**From:** Nolan, Chris <Chris.Nolan@lancashire.gov.uk>  
**Sent:** 09 February 2018 13:18  
**To:** Rachel Horton; planning  
**Cc:** LHS Customer Service  
**Subject:** D3.2017.1066 - AMENDMENT - Unit A, Whalley Ind Park, Clitheroe Rd

Planning Application No: 3/2017/1066  
Grid Ref: 373635 437604  
Proposal: Proposed COU from existing B1 (light industrial) to D2 (Gym) with associated parking (7 bays) in front of Unit 16.  
Location: Unit A Whalley Industrial Park Clitheroe Road Whalley BB7 9WP

SITE BLOCK PLAN

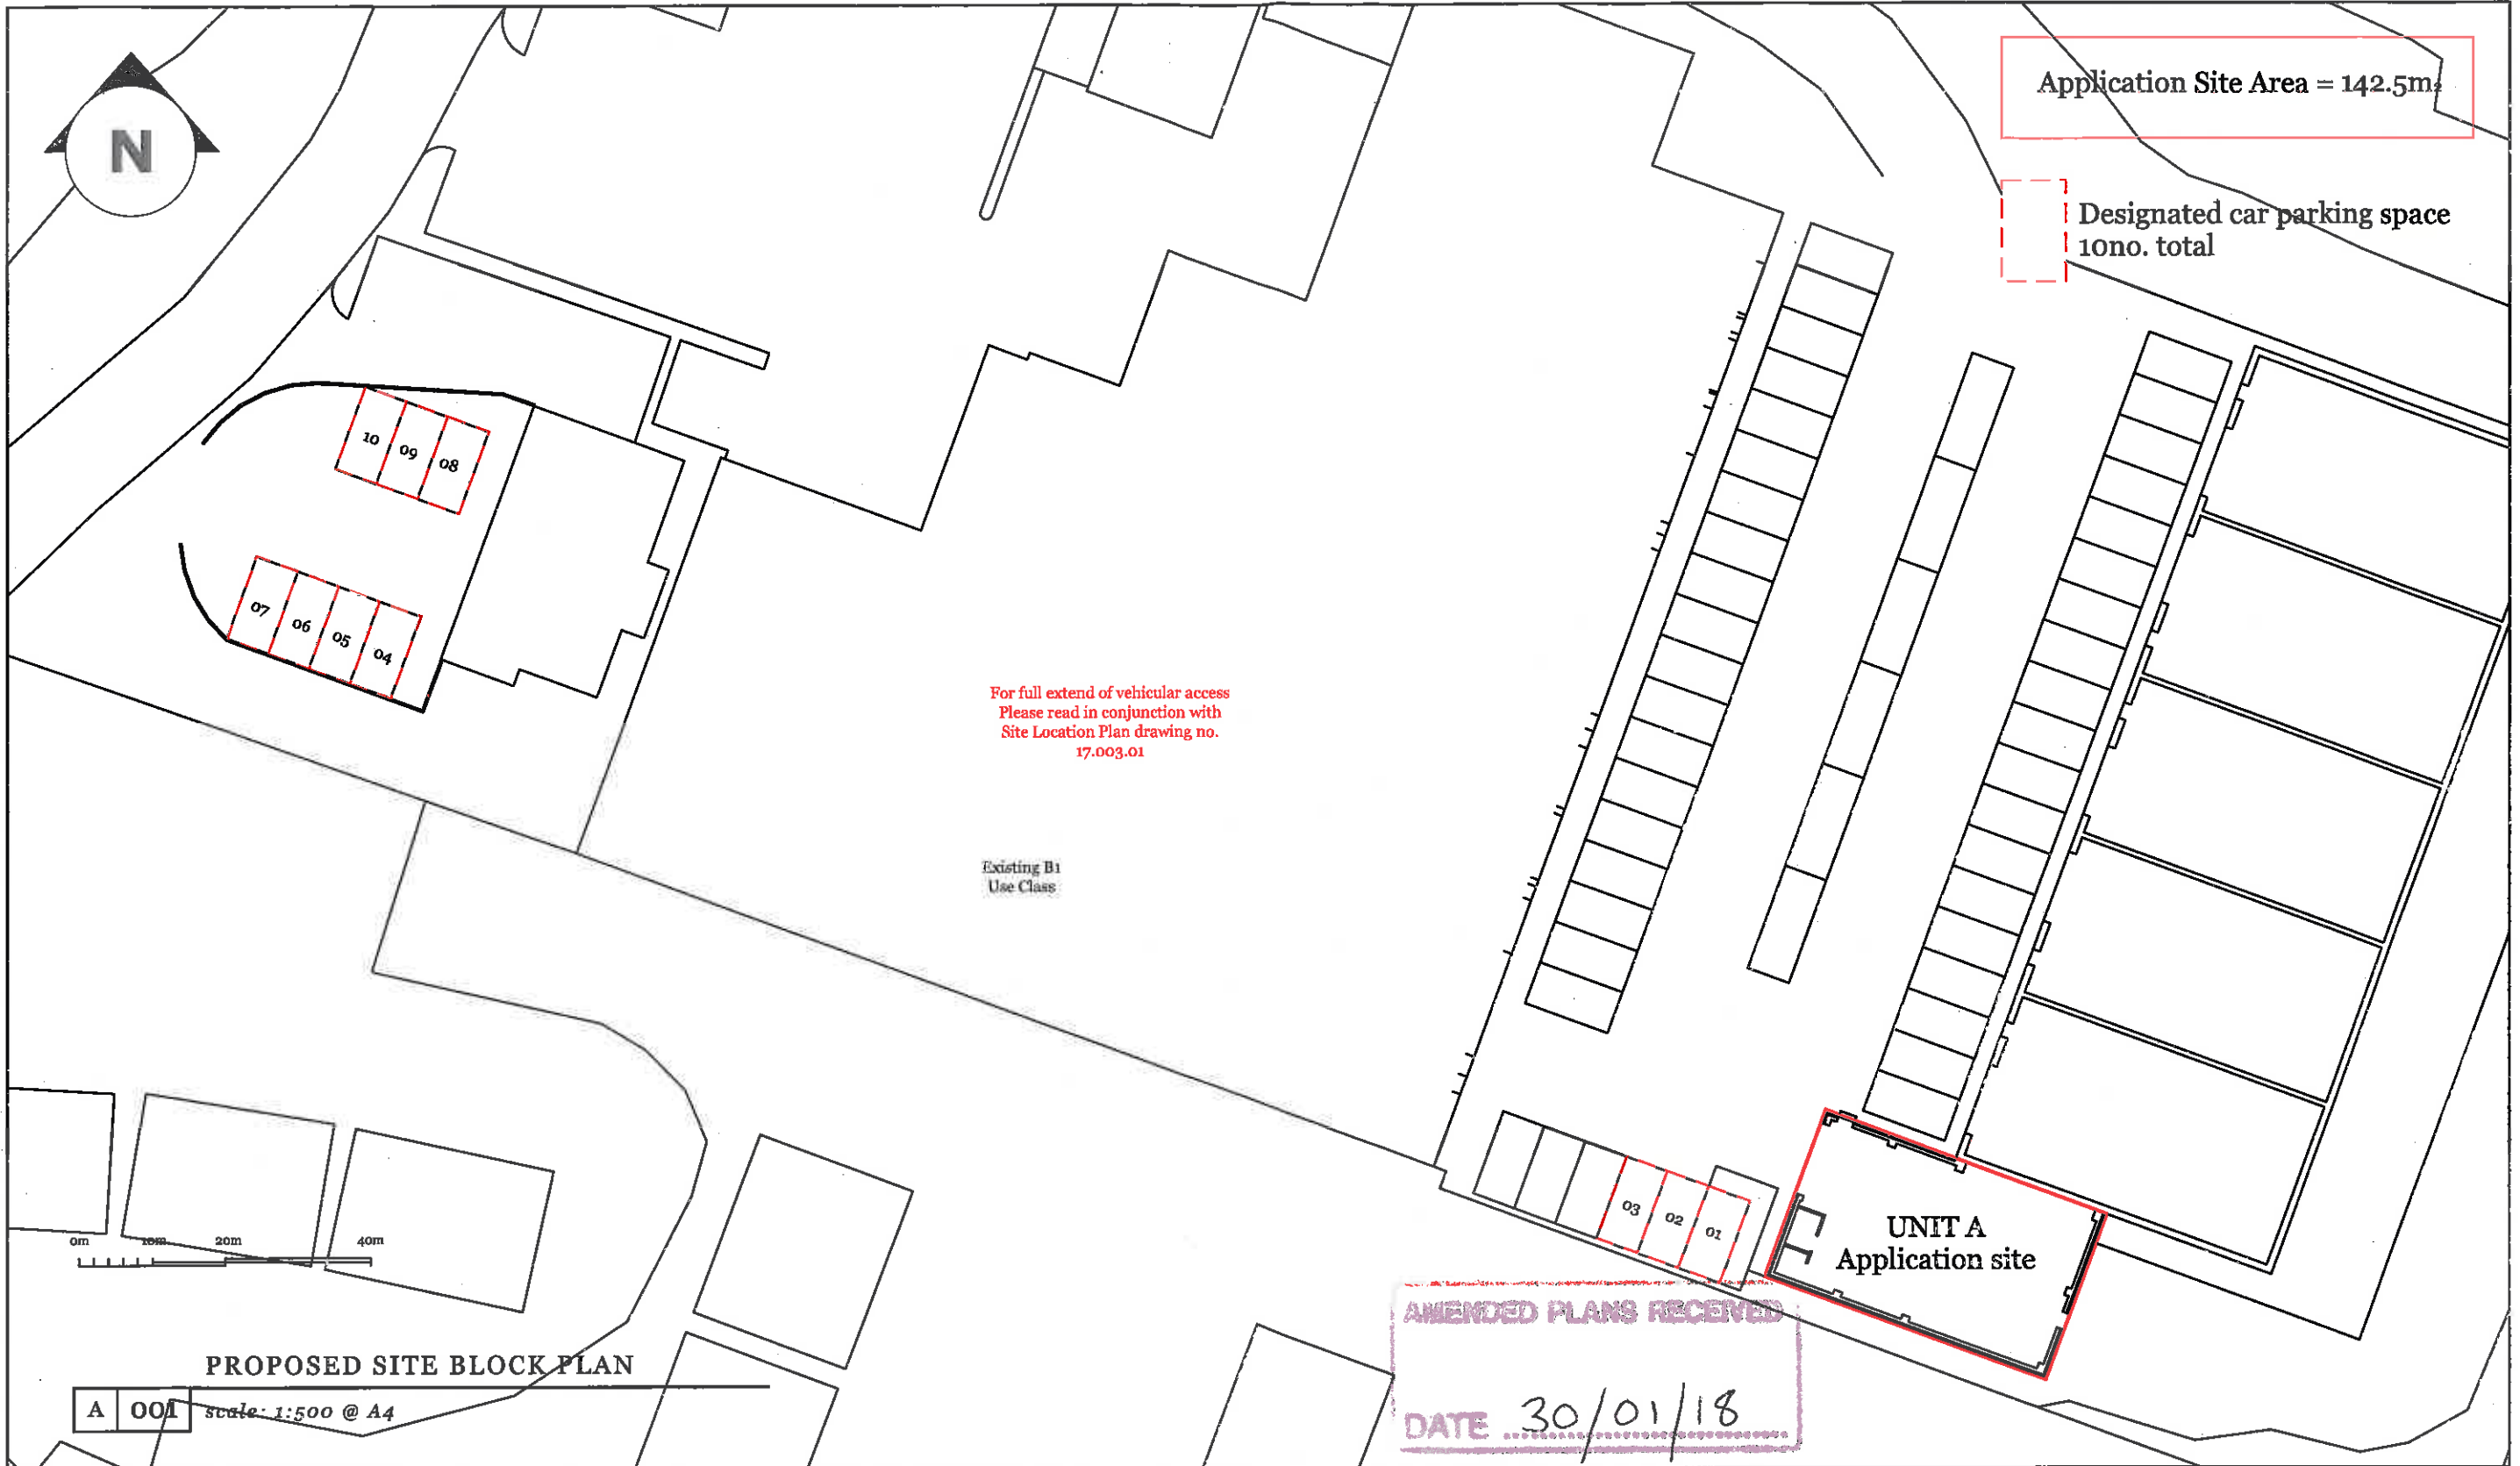
With regard to the above amended application to change a Light Industrial Unit to a Gym. The amendment is to allocate seven parking bays for the site at the entrance to the industrial estate whilst the Gym is proposed to be in the building that is the last unit on the estate an estimated 190m from the allotted parking area. The pedestrian route would be through the car park serving several industrial units and as such would not be reasonable to ask customers to undertake this walk. I would also note that the allocated area is regularly parked up and therefore would need to be correctly marked if it were to be reserved for the Gym. I feel that as the site is both close to the main industrial park entrance and some distance from the Gym then it would not be possible to ensure that the parking would be reserved for Gym customers and staff.

I am of the opinion that the proposed parking arrangements are not suitable and therefore I am unable to accept these as the required parking for the proposed change of use. I would ask the developer to look at other options that would allow 10 suitable parking places to be provided as Gym Parking prior to being able to agree that the change of use is acceptable. As in my earlier communications I would have to have evidence that the parking bays could be reserved for Gym use and that these would be suitably signed to convey that measure.
